**FULL PLANNING APPLICATION FOR THE
DEMOLITION OF BUILDINGS 485 AND 488 AND
THE ERECTION OF 43 DWELLINGS WITH
ASSOCIATED PARKING, INFRASTRUCTURE,
LANDSCAPING AND PUBLIC OPEN SPACE**

**DORCHESTER PHASE 6, HEYFORD PARK, CAMP
ROAD, UPPER HEYFORD**

**PLANNING, HERITAGE AND DESIGN
STATEMENT ADDENDUM**

ON BEHALF OF DORCHESTER GROUP

Chimney to plots 311 & 312 only

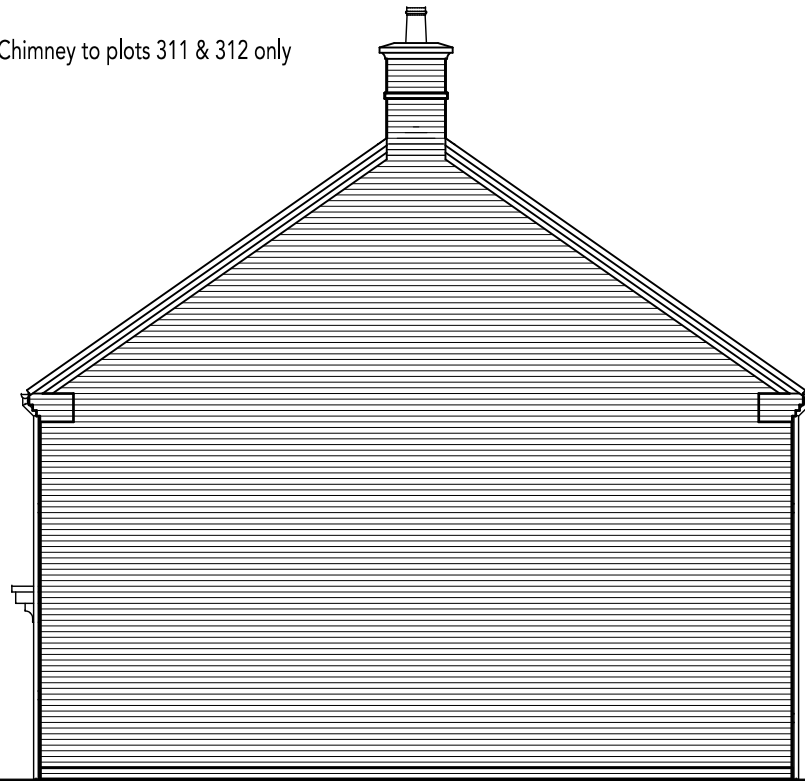
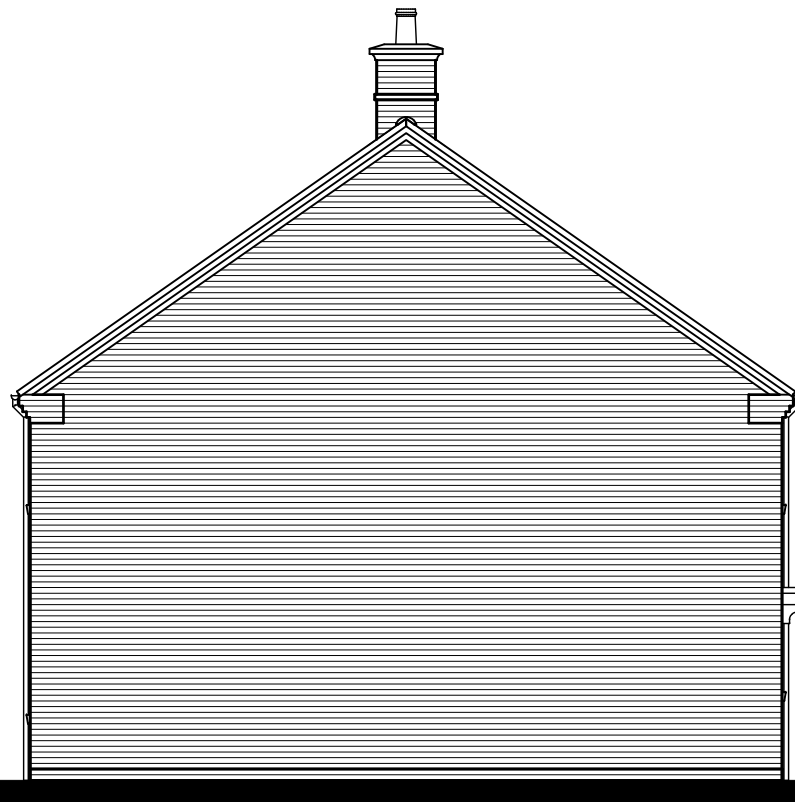
- Chimneys added to the affordable properties so that they are indistinguishable from the open markets dwellings – added to Plots 311/312 and 323/324/325;
